## KITTITAS COUNTY FIRE MARSHAL'S OFFICE

January 28, 2026

Fire Marshal comments  
Quiet Cadence Farm  
PM-26-00002

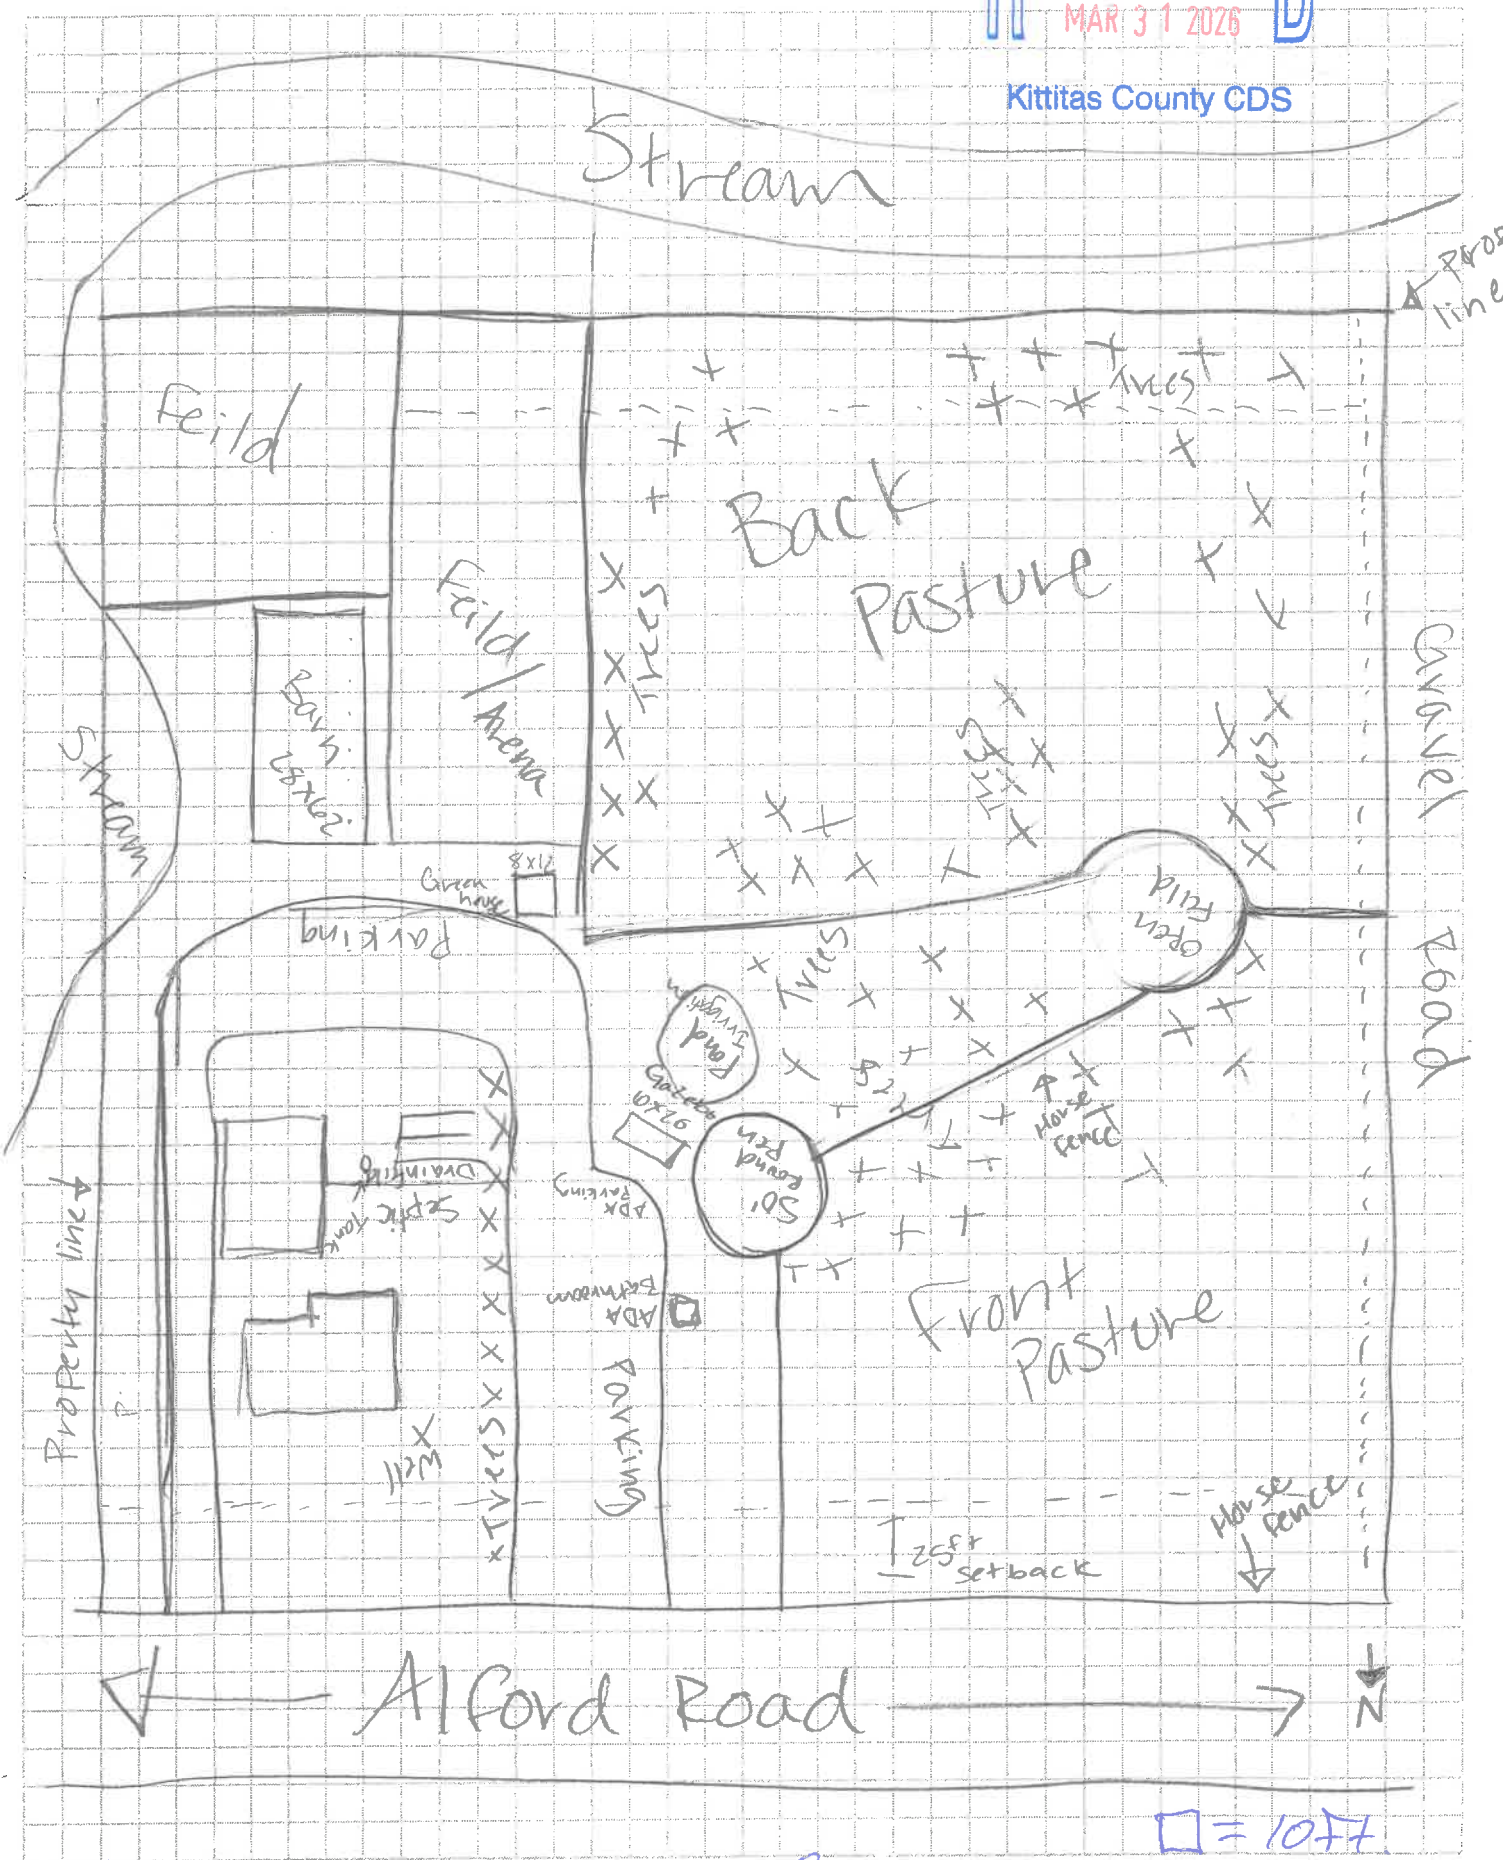
Fire apparatus access is required for this application. The roadways and maneuvering areas as indicated in the application do not adequately provide required fire apparatus access. Provide fire apparatus access roads with an unobstructed width of not less than 20 feet, an unobstructed vertical clearance of not less than 13.5 feet, with an all-weather driving surface and capable of supporting the imposed loads of fire apparatus. Access roads shall extend to within 150 feet of all portions of the facility and all portions of the exterior walls of the first story of the building.

Approved fire apparatus turnarounds are required for this project. The indicated provisions for turning around fire apparatus are not adequate. Provide a turnaround meeting the requirements of the International Fire Code Appendix D.
